## OFFICIAL NOTICE OF DECISION

CITY OF ALBUQUERQUE  
PLANNING DEPARTMENT  
DEVELOPMENT REVIEW BOARD

**Project# 1007140**  
12DRB-70177 EXT OF MAJOR PRELIMINARY PLAT

MARK GOODWIN AND ASSOCIATES, P.A. agent(s) for JTH, LLC request(s) the above action(s) for all or a portion of Lot(s) 2A, **JUAN TABO HILLS UNIT 3B** zoned RD-SU1, located on JUAN TABO BLVD BETWEEN MONACHOS RD AND TIJERAS ARROYO containing approximately 9.54 acre(s). (M-22)

TITLE: **JUAN TABO HILLS UNIT - 3B  
 GRADING & DRAINAGE PLAN**

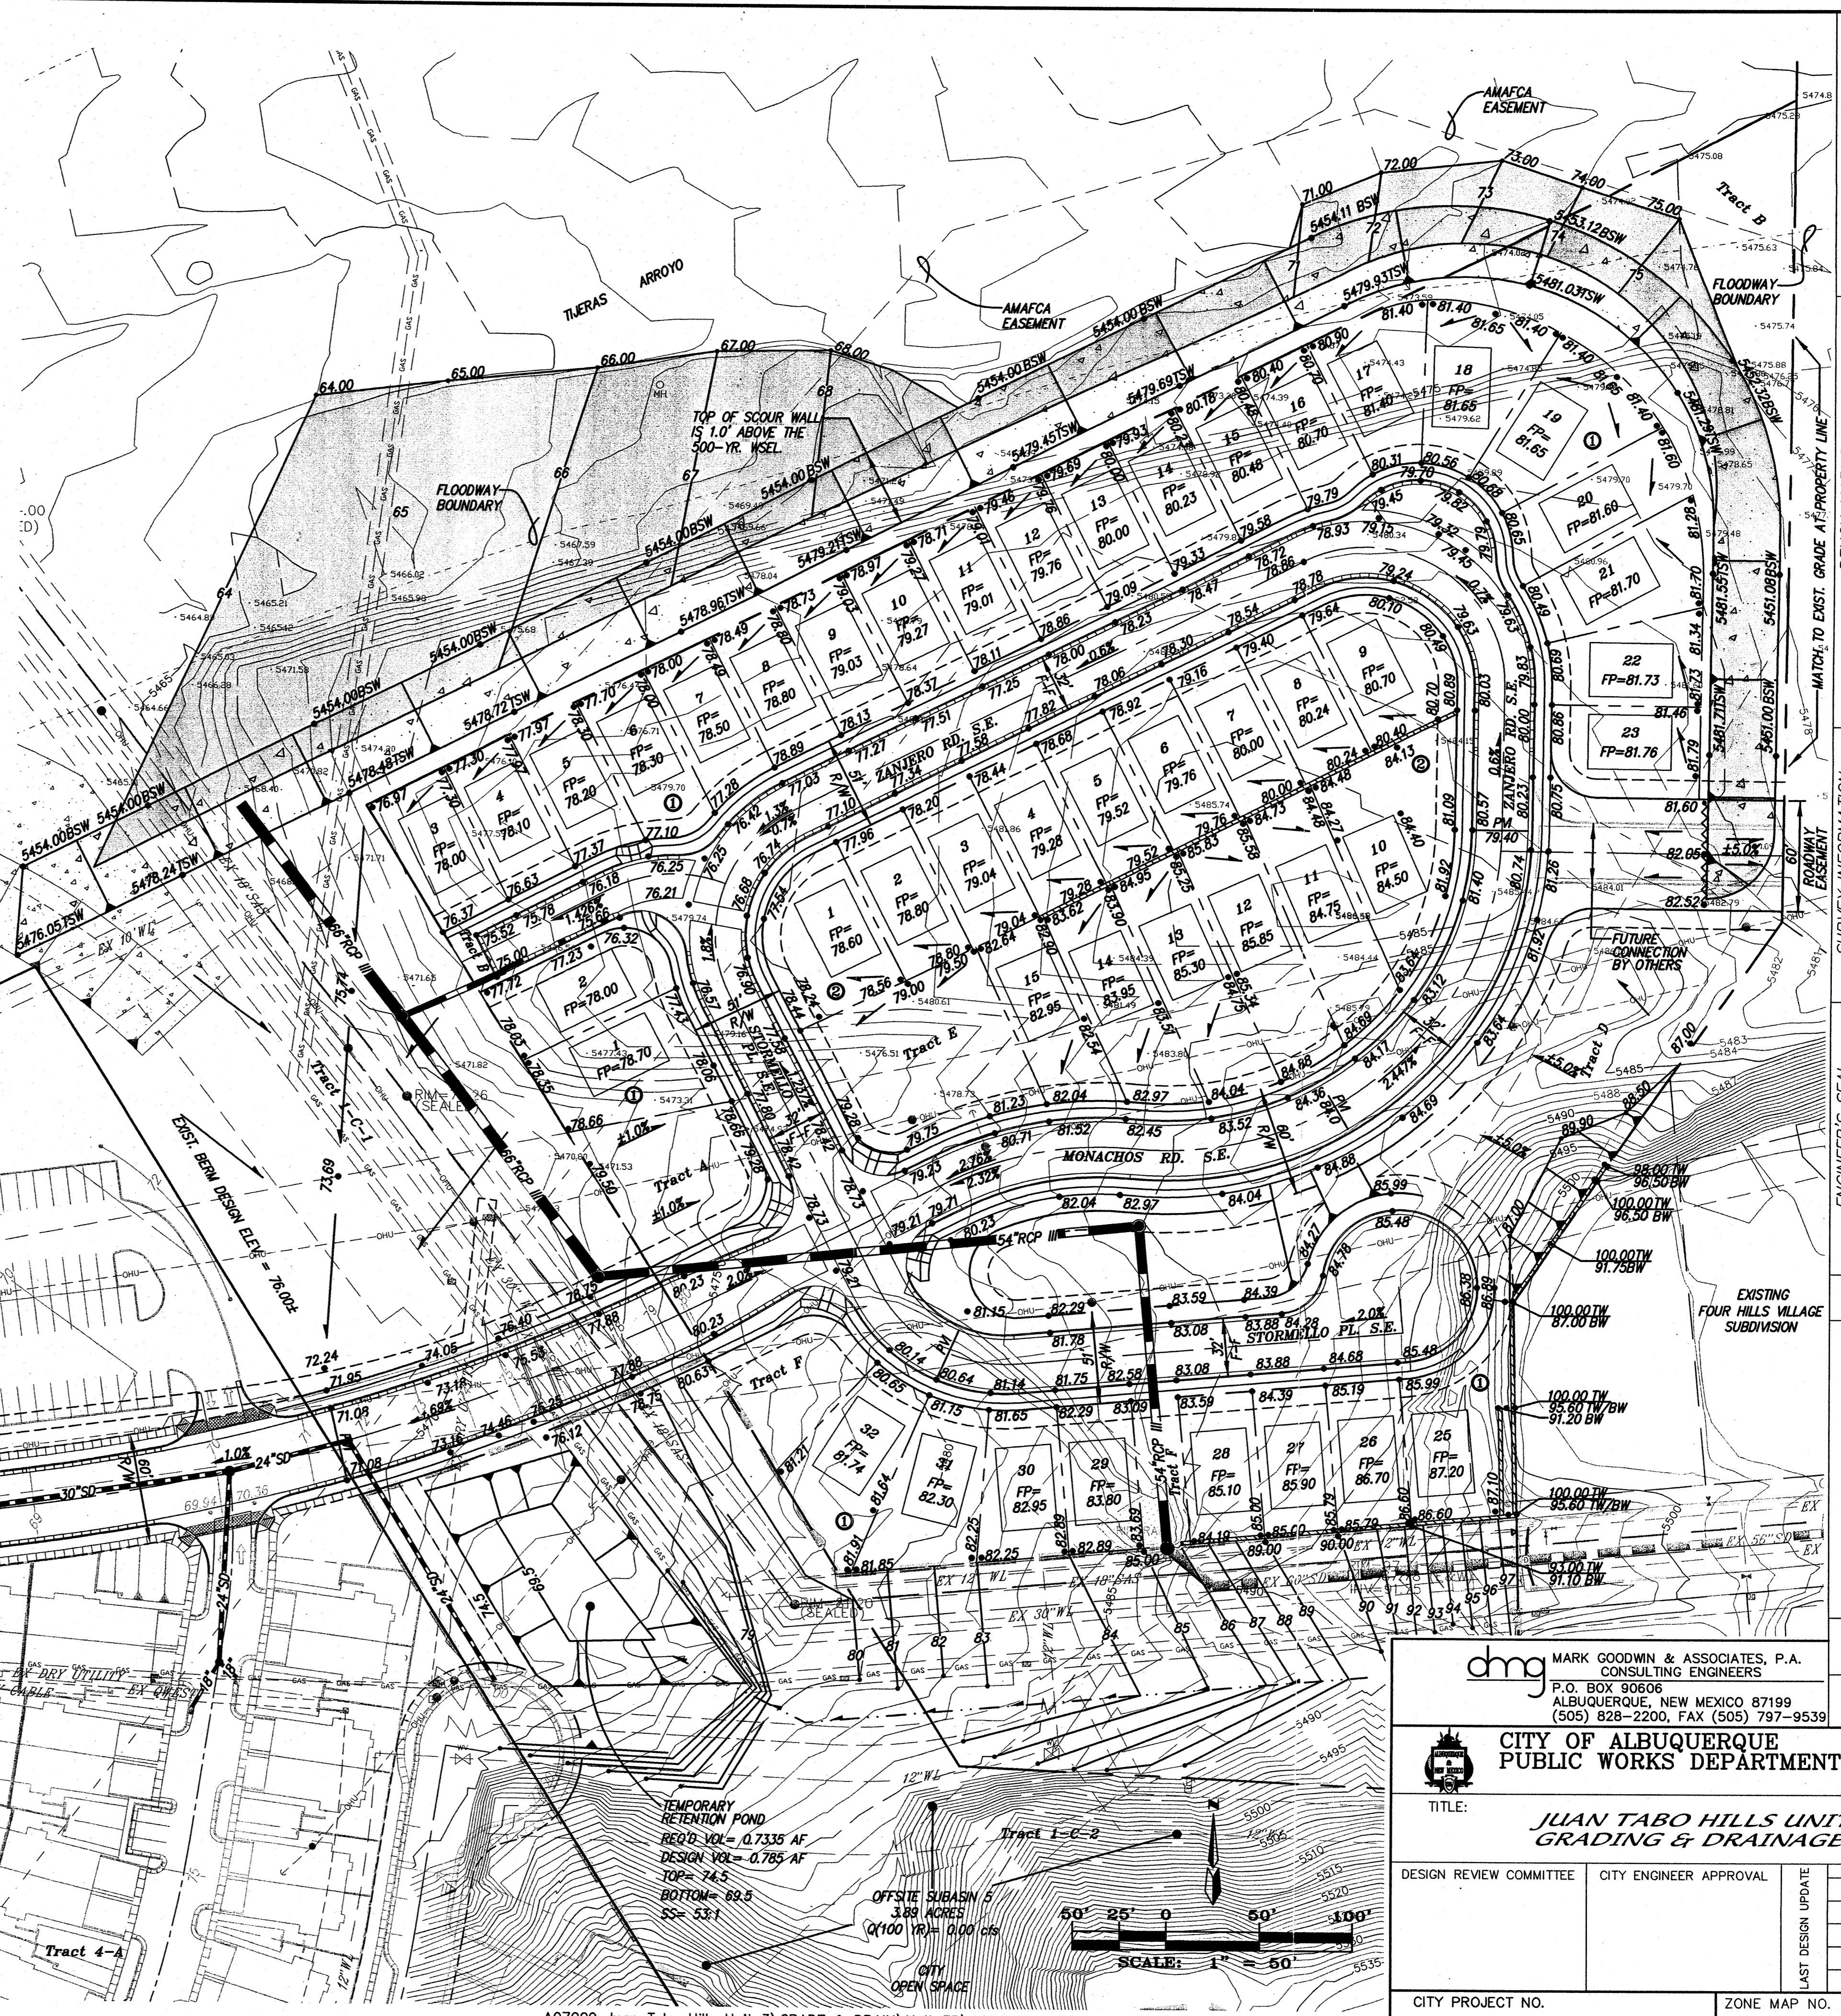
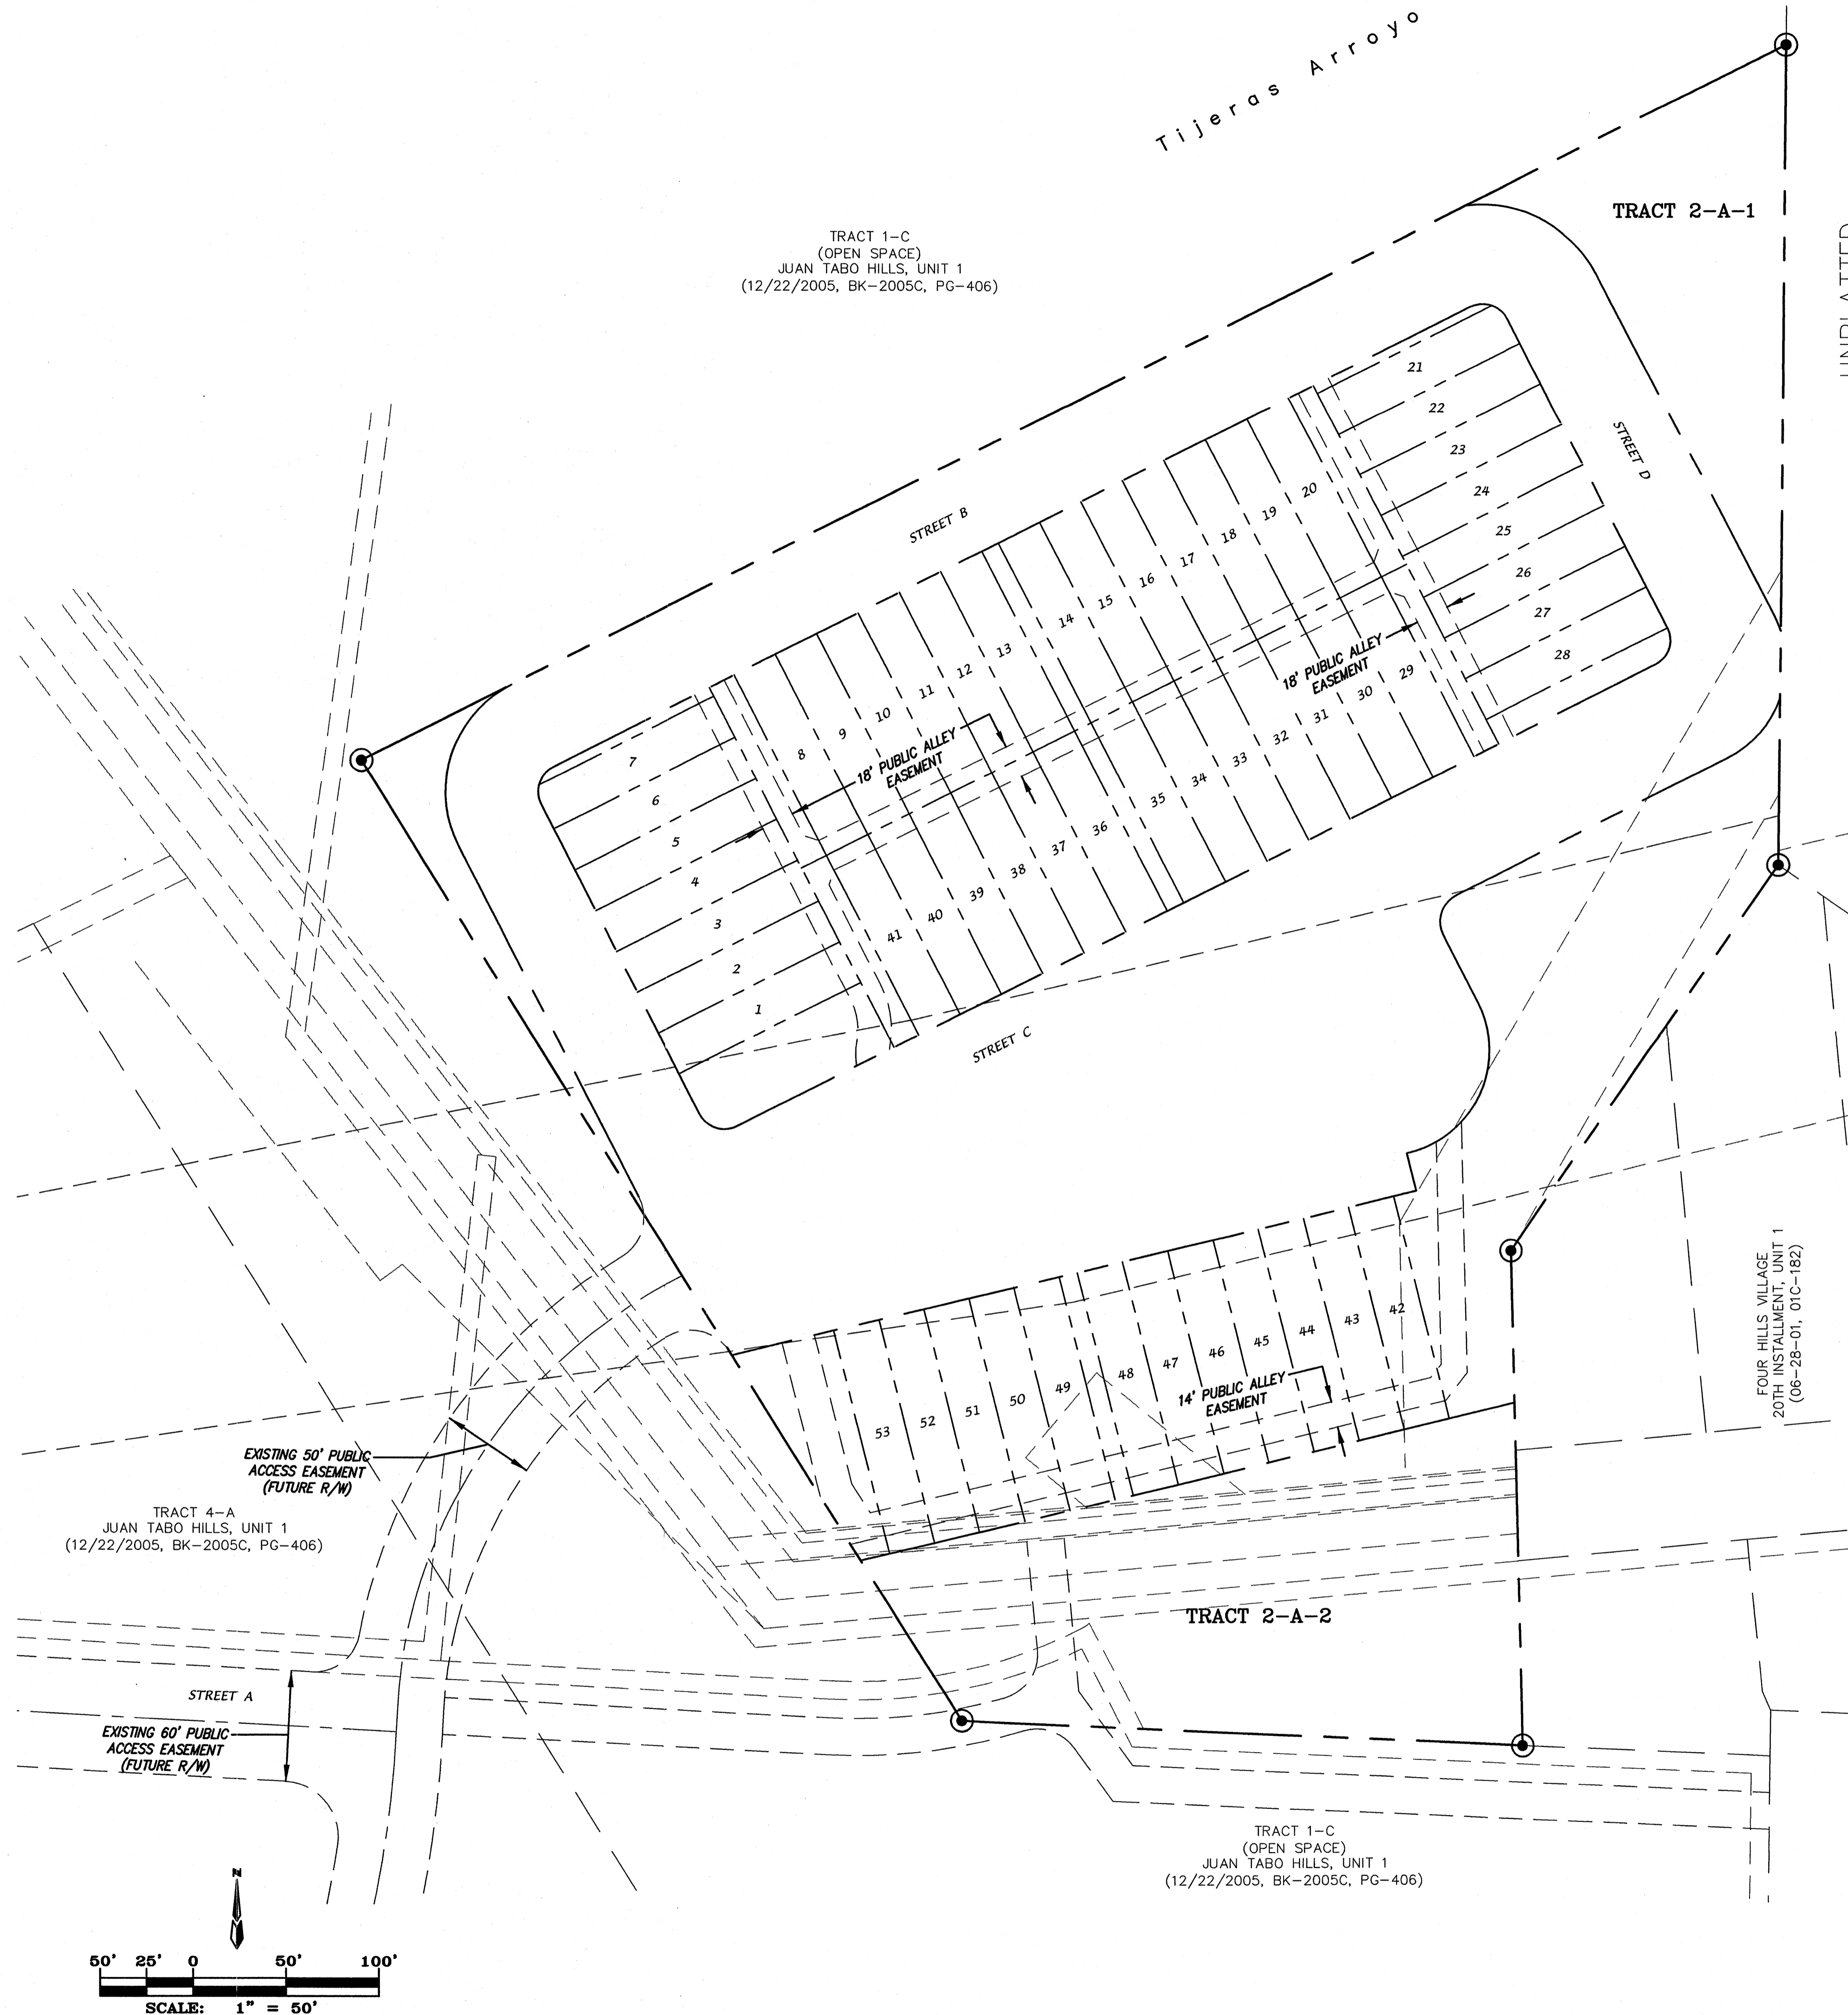
3. It will be necessary to have current and effective vacation approvals as needed and previously approved for the proposed plat.
4. An amended grading and drainage plan for Unit 3-B, Unit 3A and Tracts 1-C-1 and 1-C-2 must be submitted and approved by the Development Review Board.

6. Provide a written reason for not recording a Subdivision Improvement Agreement 3 years after the original Preliminary Plat approval.
7. Keyed Note 25 notes there is a 51 foot wide Public Access Easement granted to the City of Albuquerque for Tract A which may interfere with the scour wall shown on the Grading and Drainage Plan that needs to be addressed.
